26 November 2020

The Hon. Rob Stokes MP  
Minister for Planning and Public Spaces  
GPO Box 5341  
Sydney NSW 2001

### **Major Project: Weigall Sports Complex, Sydney Grammar School**

Location Description:
Living room of unit 9,
8 Vialoux Avenue

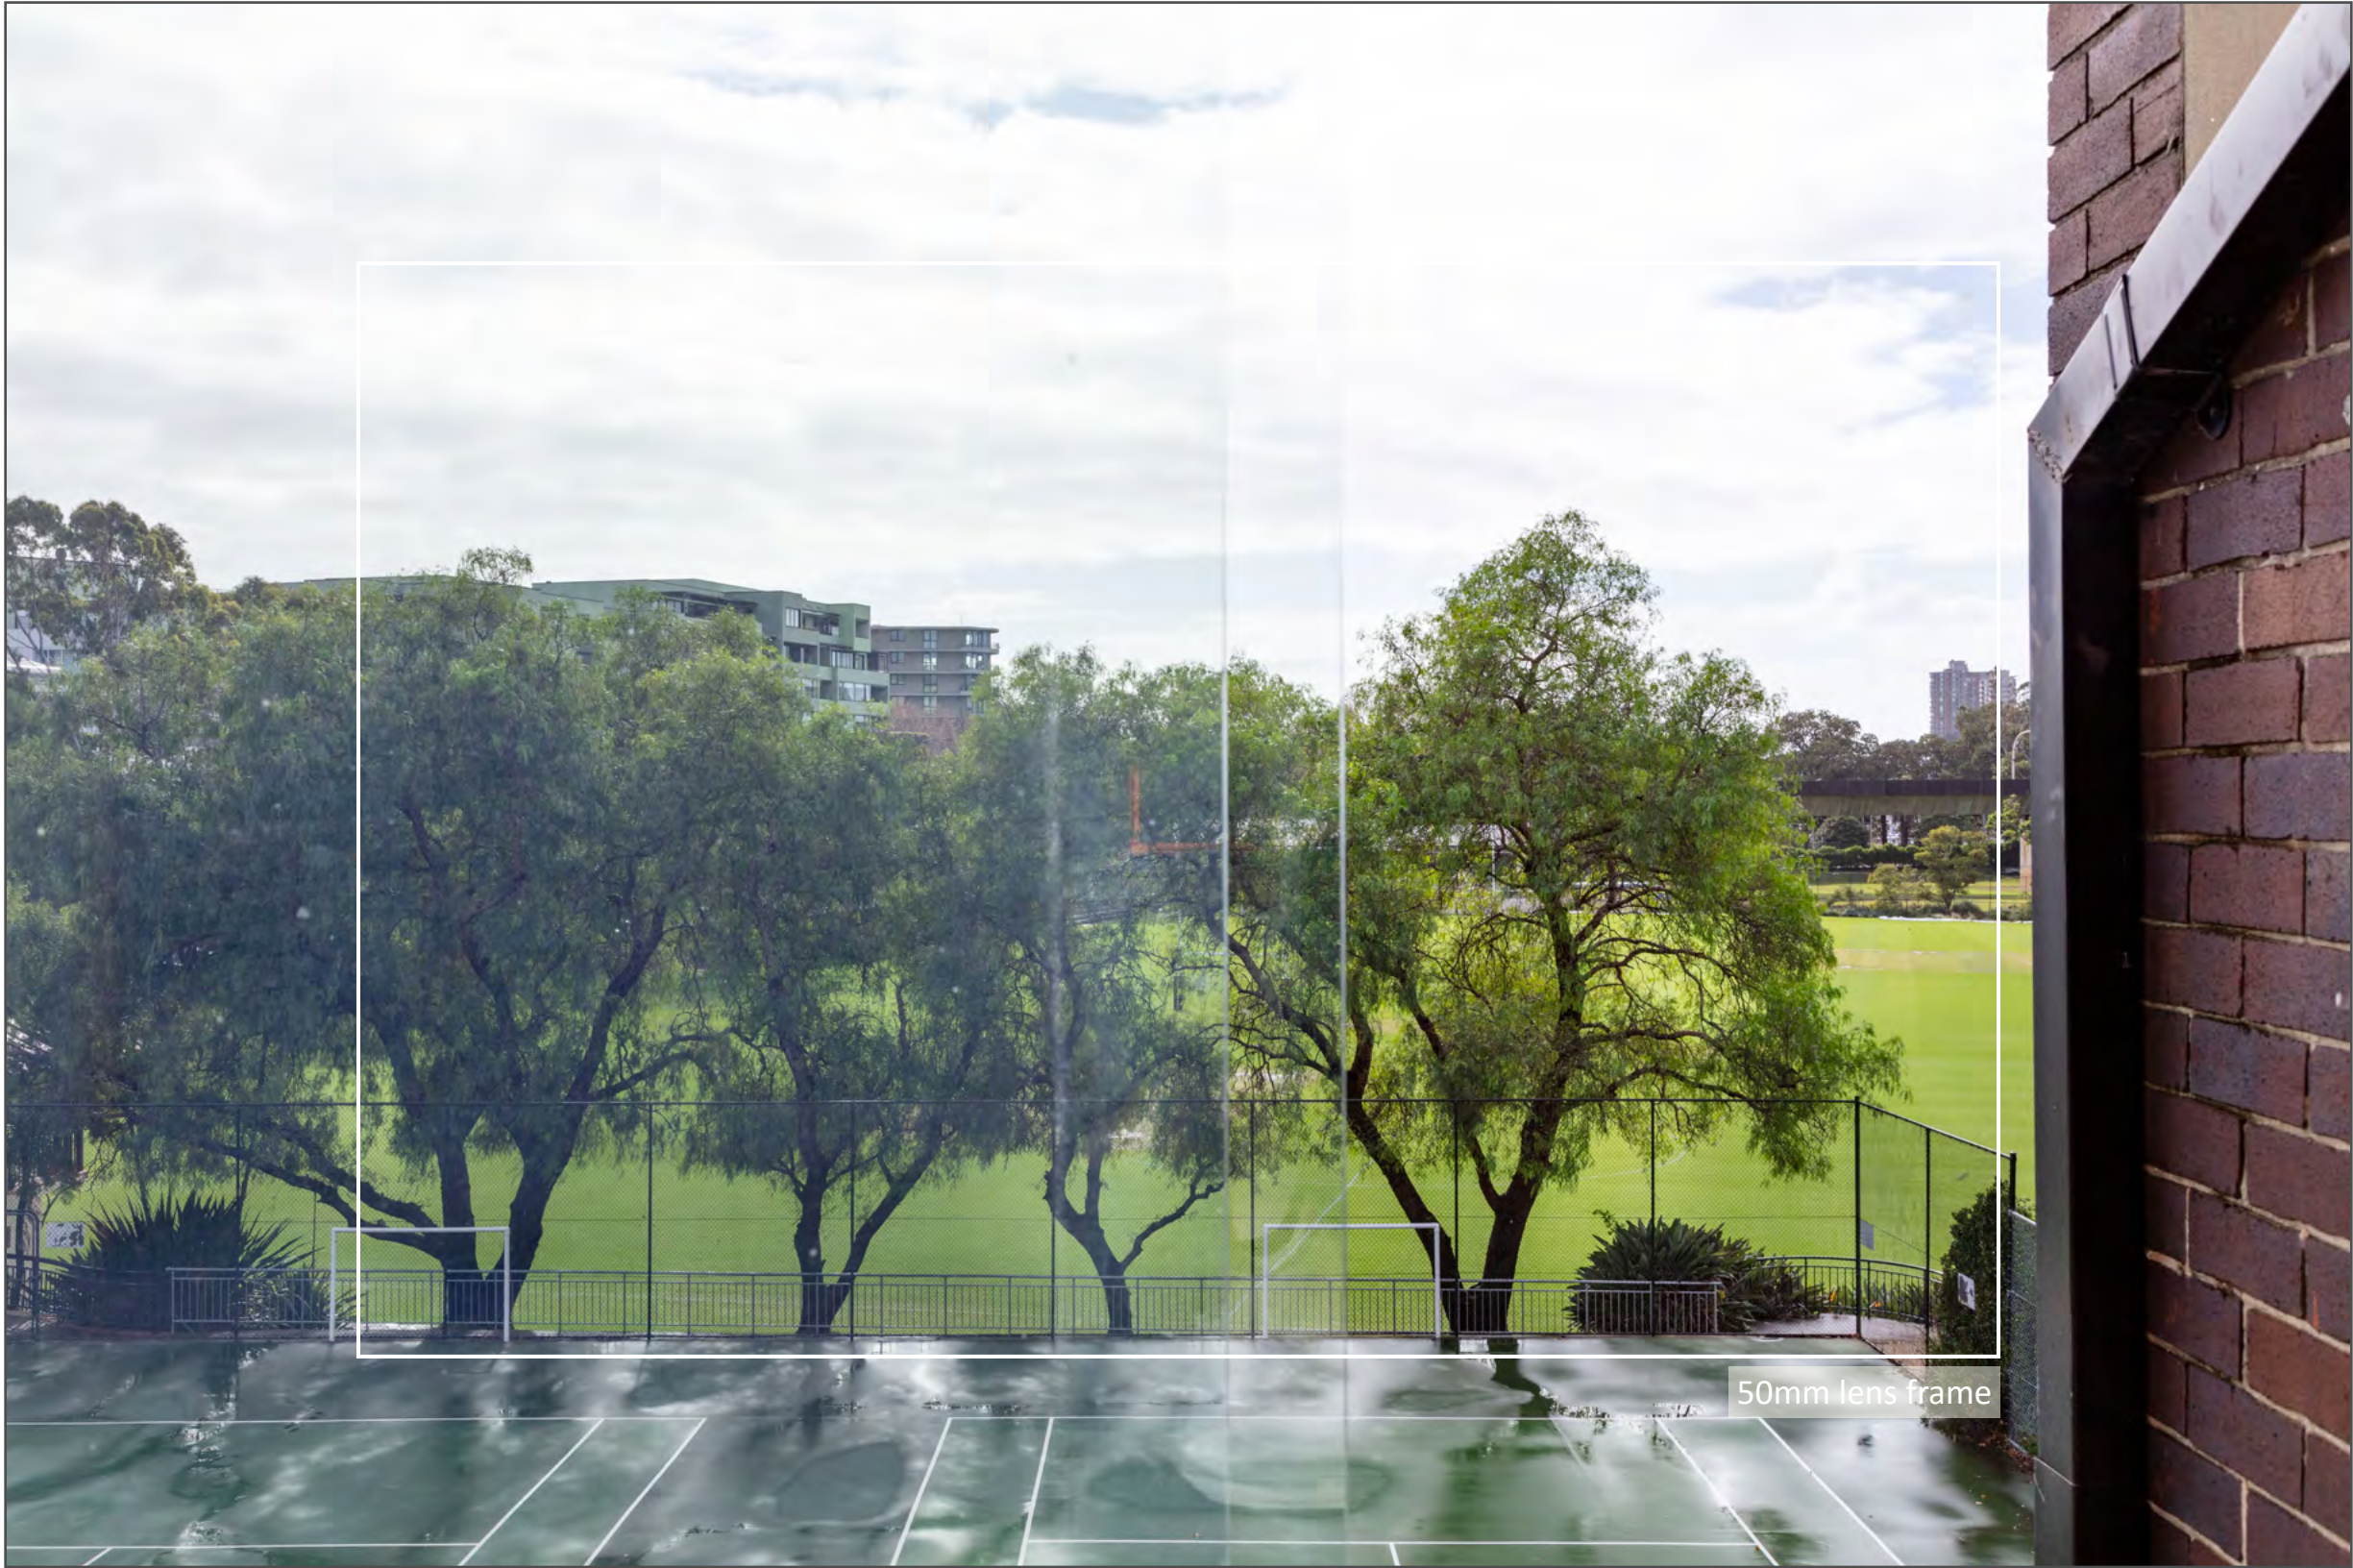
Homes at 18 Neild Avenue and 8 Vialoux Avenue will have the views from their apartments devastated and eliminated, replaced by a heavy built wall. Views are important to the wellbeing of apartment residents, who live with no private open space. A view can connect someone inside an apartment with the outside world and create a sense of space and this impact will affect residents' quality of life.
